City of Albuquerque

August 31, 2001

RE: Grading and Drainage Plan for Edith Blvd. and Granite Ave. NE (J-14/ D141), Engineer's stamp dated August 28, 2001. (J-14,15)

FILE:
010401 - GAHP-CRESPIN
-SITE

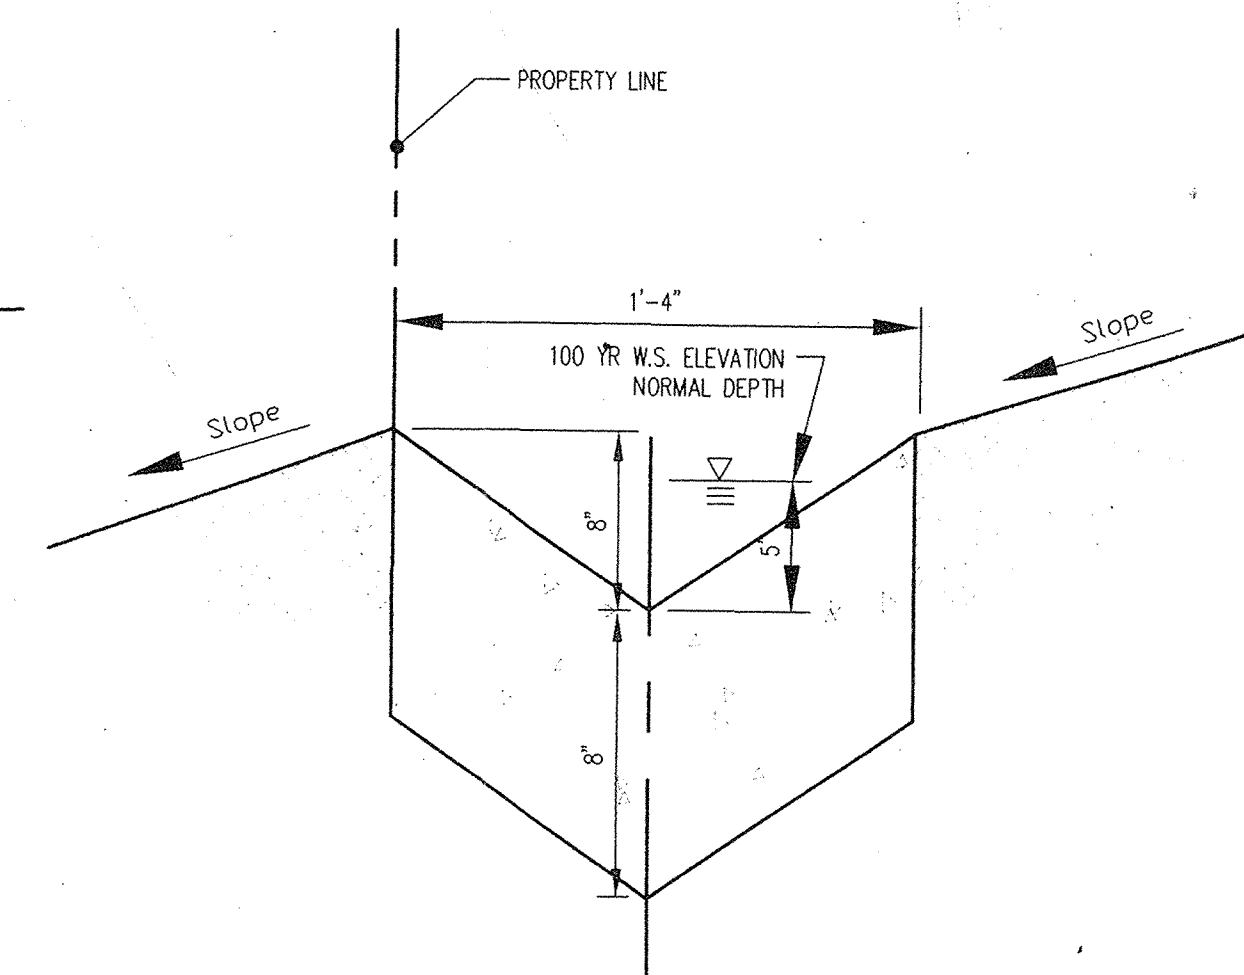
1. Comment 6 from my letter to you dated August 21, 2001 regarding the finish floor of the Lot 1 garage. Your new submittal shows the garage FF lowered to 4964.20. This won't work because the sidewalk elevations immediately north of the structure are higher. Please lower the elevations of the sidewalk immediately north of the structure.
2. Per our phone conversation today, I concur that the "V" swale along the west edge of Lot 3 should be replaced by a low flood wall per the detail. This will provide greater protection for Lot 1 than the "V" swale. Please make this change to the plan. At the south end of the flood wall where the discharge will flow onto the asphalt, please provide a cutoff wall at the interface to prevent erosion under the asphalt.
